From: Thomas Bertwistle
To: Stephen Richardson
Cc: Brian Hanley; john.studdert@manildra.com.au
Subject: RE: Shoalhaven Starches - Gas Pipeline - Shoalhaven Starches Gas Pipeline Project Mod 2 - (PMA-30699588)
Date: Friday, 26 November 2021 8:37:16 AM
Attachments: [image001.png](#)
[image002.jpg](#)
[image003.png](#)
[image005.jpg](#)

Shoalhaven Starches – EPL 883
Gas Pipeline Project Mod 2

From: [Development](#)
To: [Stephen Richardson](#)
Subject: Shoalhaven Starches Gas Pipeline Project Modification 2 - COMMENTS FROM SHOALHAVEN CITY COUNCIL
Date: Friday, 21 January 2022 4:51:51 PM
Attachments: [image002.jpg](#)
[image003.png](#)

Modification 2

P.C.	DATE	SHOALHAVEN STARCHES.BOMADERRY.	A3
CHKD B.H.	06/10/21	DWG TITLE	
APPD	DATE	GAS FACILITY.MOD 2.	
SCALE 1:500		FACTORY GAS SUPPLY PIPELINE.SITE PLAN.	
PROJECT No.		7297	REV.
		MN7297-101	P06

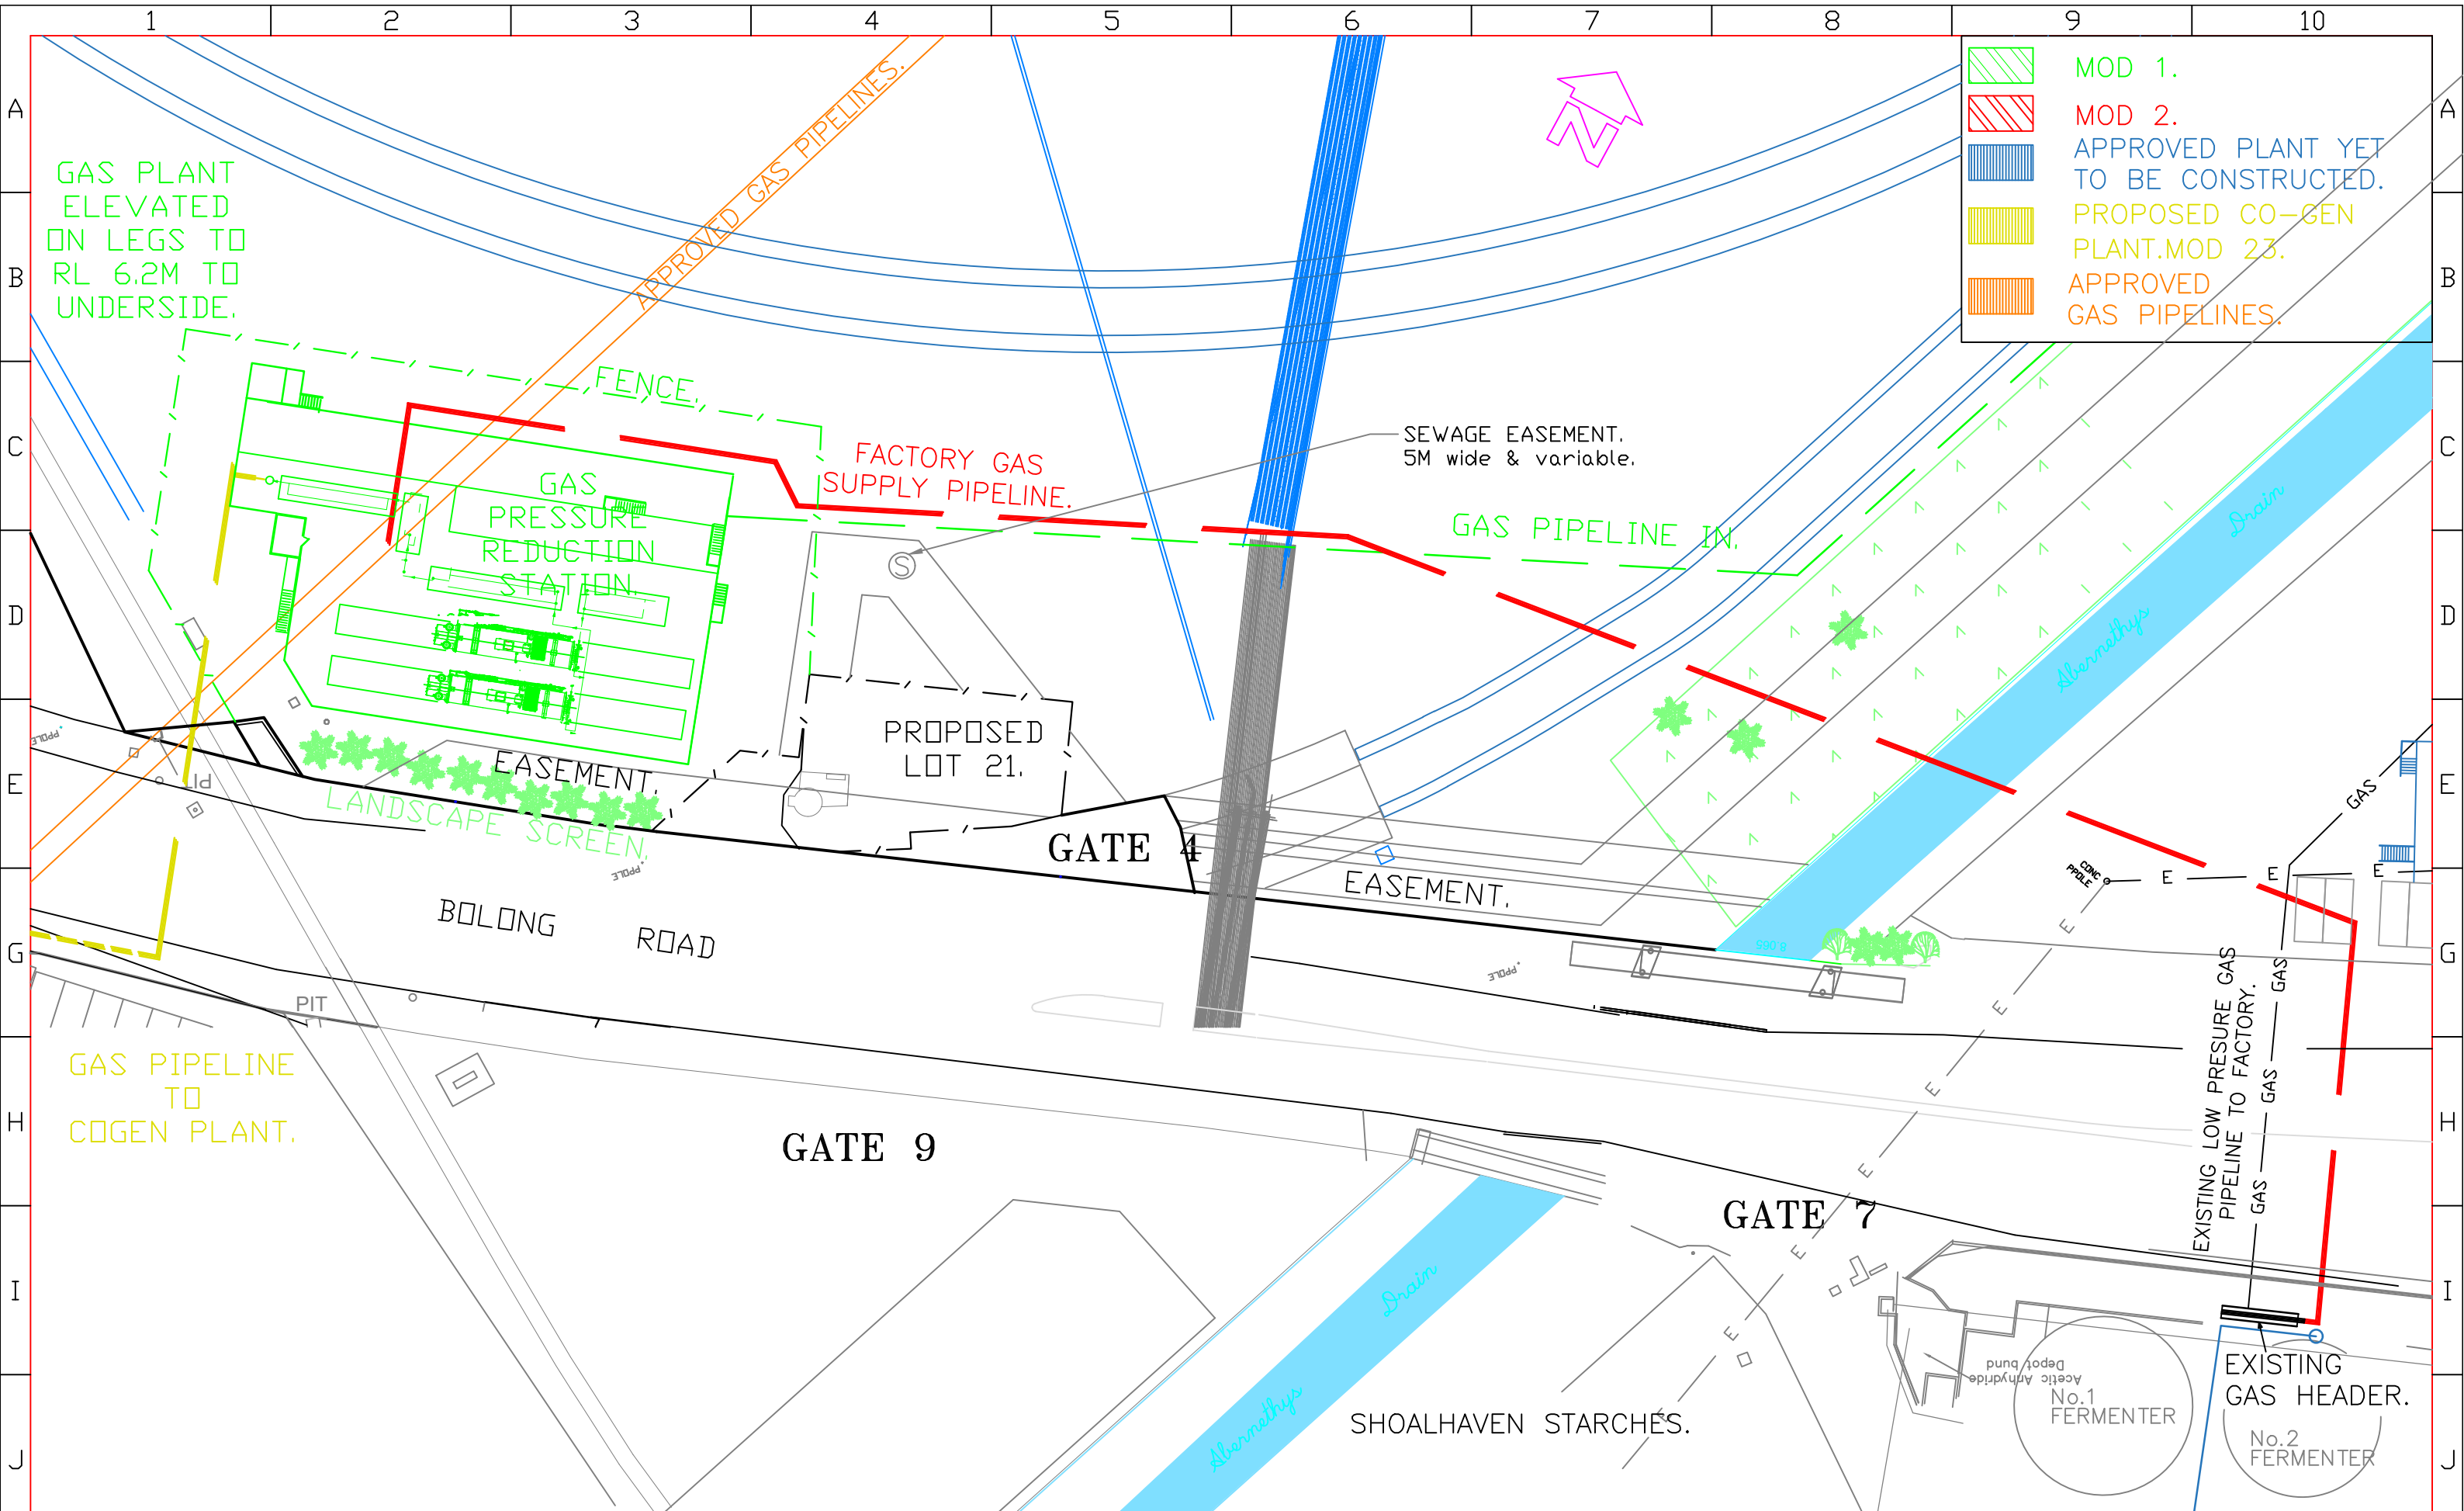
However, we do foresee biodiversity impacts potentially being an issue, as this extension is crossing another water body and riparian vegetation corridor. In its assessment, the Department will have to be satisfied that there are no further biodiversity impacts over the original assessment in order to not require a BDAR. Due to this, the modification report should include discussion on the impacts on vegetation and the construction method crossing the riparian area.

3. In relation to riverbank stability, it is considered that an assessment should be undertaken of the potential impacts that the proposed relocated gas pipeline will have on the stability of the banks of Abernethy's Creek and any recommendations to mitigate such impacts. It is requested that the proposed modifications to the development observes the relevant principals of section 5 of the Water Management Act 2000.

Figure 3 | Route of pipeline extension

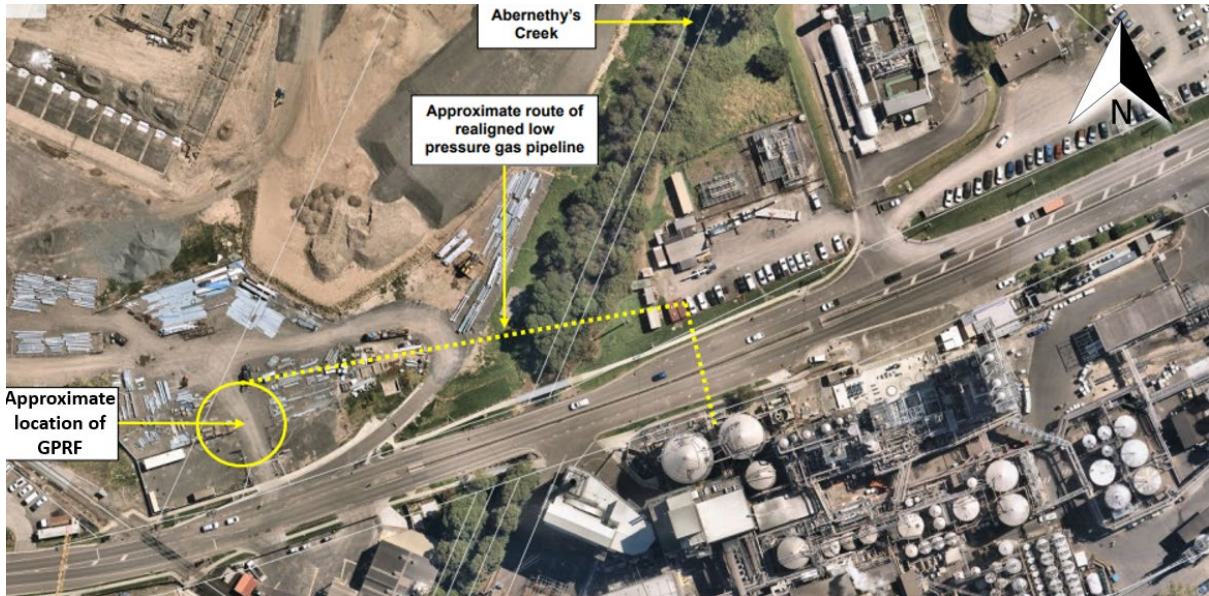
I understand the project crosses existing water bodies through boring, so I am assuming it would be a similar case for this crossing?

1. It is requested that the construction methodology for how the pipeline is to cross Abernethy's Creek be provided with the application. It is also noted that detailed survey of the constructed pipeline will be conditioned to be provided to Council, i.e. Work-as-executed plans.
